CITY OF PORTLAND BUILDING PERMIT

Located At 25 LENNOX ST

Job ID: 2012-07-4408-ALTR

has permission to 576 Sq Ft Addition to Existing Single Family
provided that the person or persons, firm or corporation accepting this permit shall comply with all of the provisions of the Statutes of Maine and of the Ordinances of the City of Portland regulating the construction, maintenance and use of the buildings and structures, and of the application on file in the department.

1 PLOT PLAN
Scale: 1/16" = 1'-0"

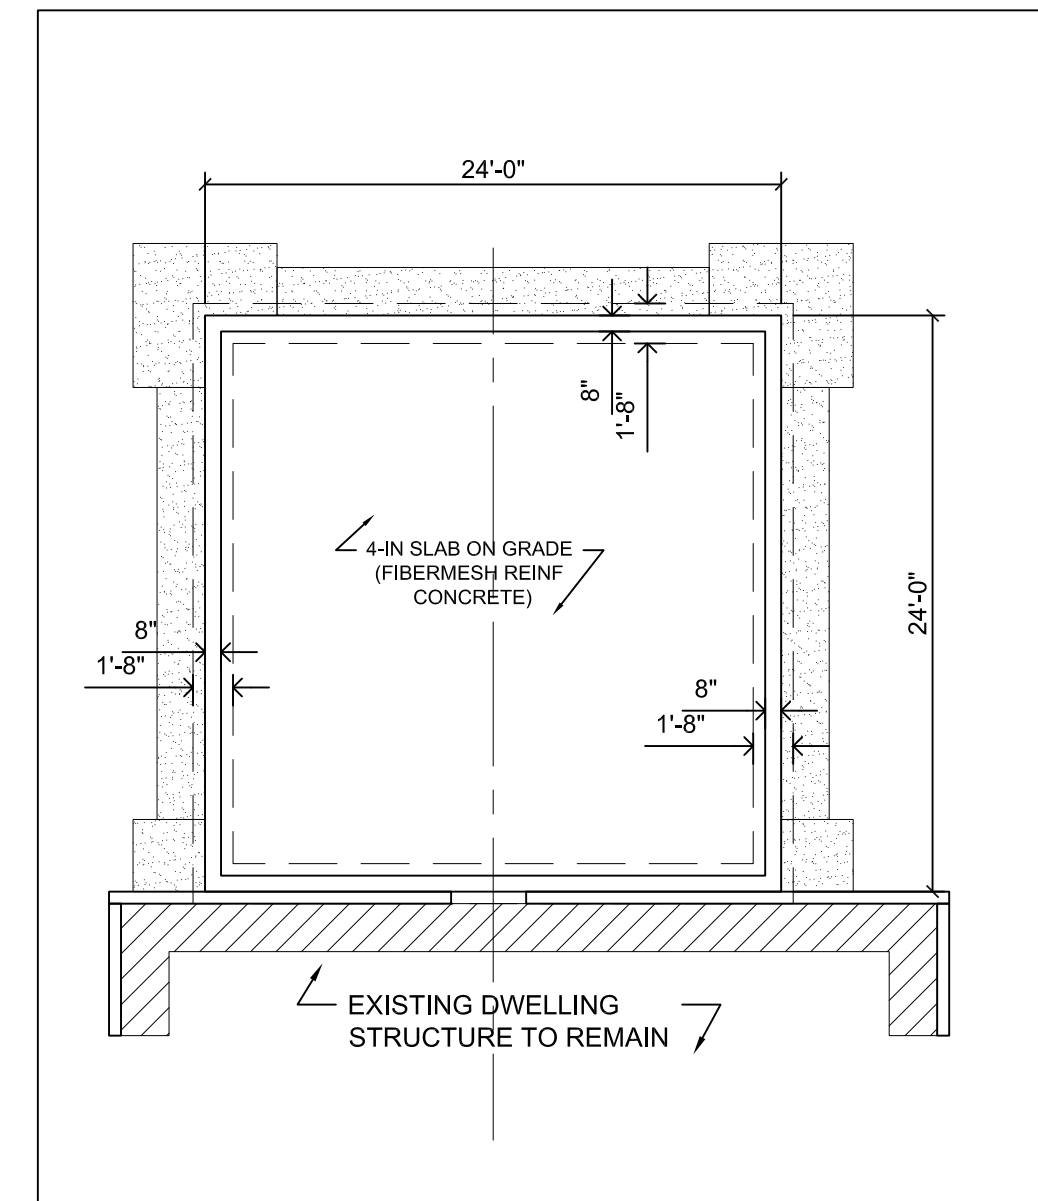
1. This permit is being approved on the basis of plans submitted. Any deviations shall require a separate approval before starting that work.
2. As discussed during the review process, the property must be clearly identified prior to pouring concrete and compliance with the required setbacks must be established. Due to the proximity of the setbacks of the proposed addition, it may be required to be located by a surveyor.
3. This property shall remain a single family dwelling. Any change of use shall require a separate permit application for review and approval.

6 NORTHWEST ELEVATION
Scale: 1/8" = 1'-0"

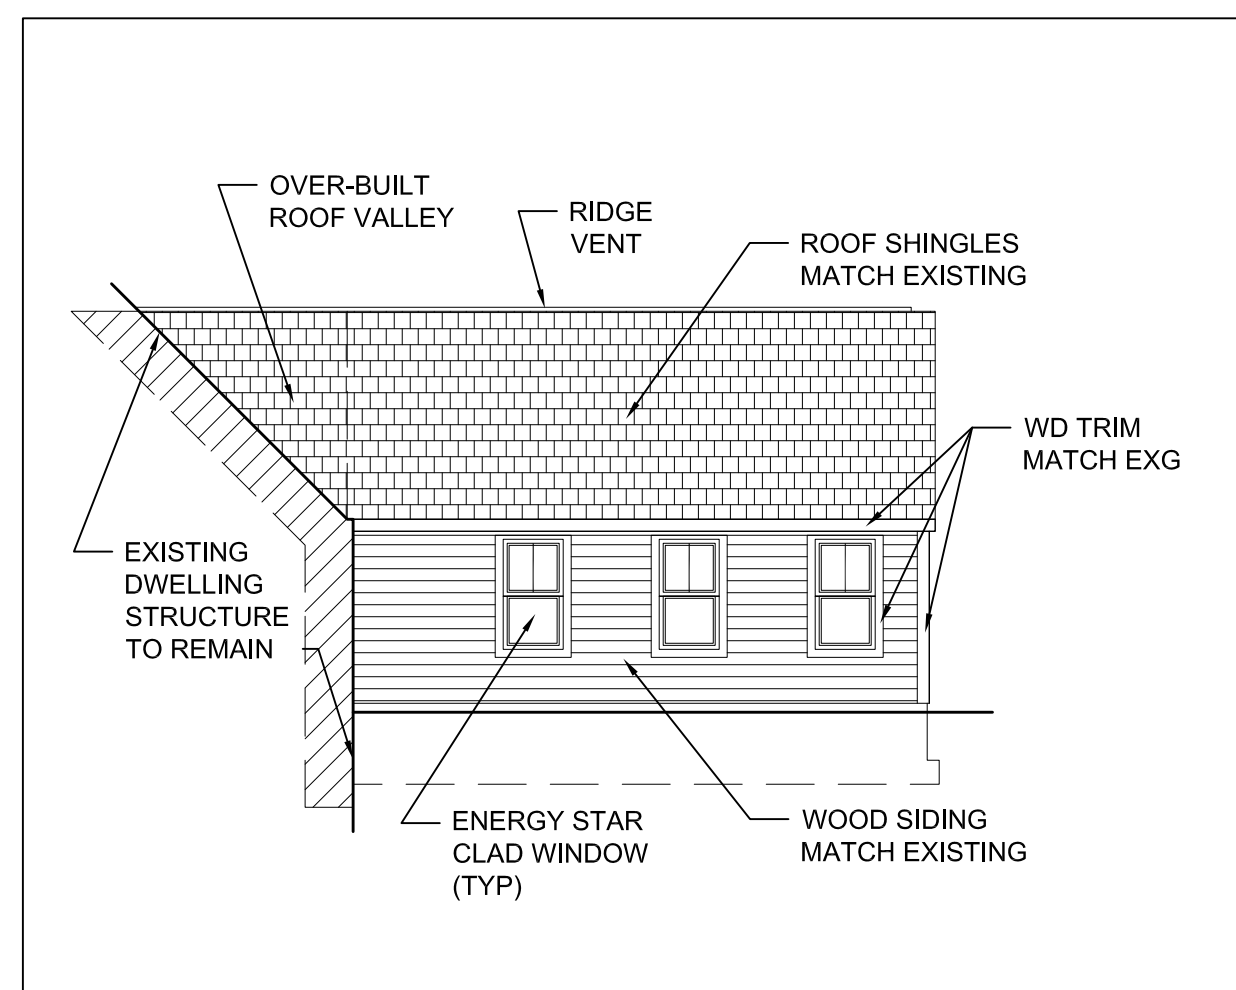
1. Hardwired interconnected battery backup smoke detectors shall be installed in all bedrooms, protecting the bedrooms, and on every level.
2. Separate permits are required for any electrical, plumbing, sprinkler, fire alarm HVAC systems, heating appliances, commercial hood exhaust systems and fuel tanks. Separate plans may need to be submitted for approval as a part of this process.
3. Application approval based upon information provided by the applicant or design professional. Any deviation from approved plans requires separate review and approval prior to work.
4. Frost protection must be installed at a minimum of 4'-0" below grade. Your plan shows 2'-0" which does not meet the code.
5. All headers must be a minimum of 2-2"x6"-s.
6. The attic scuttle opening must be 22" x 30".
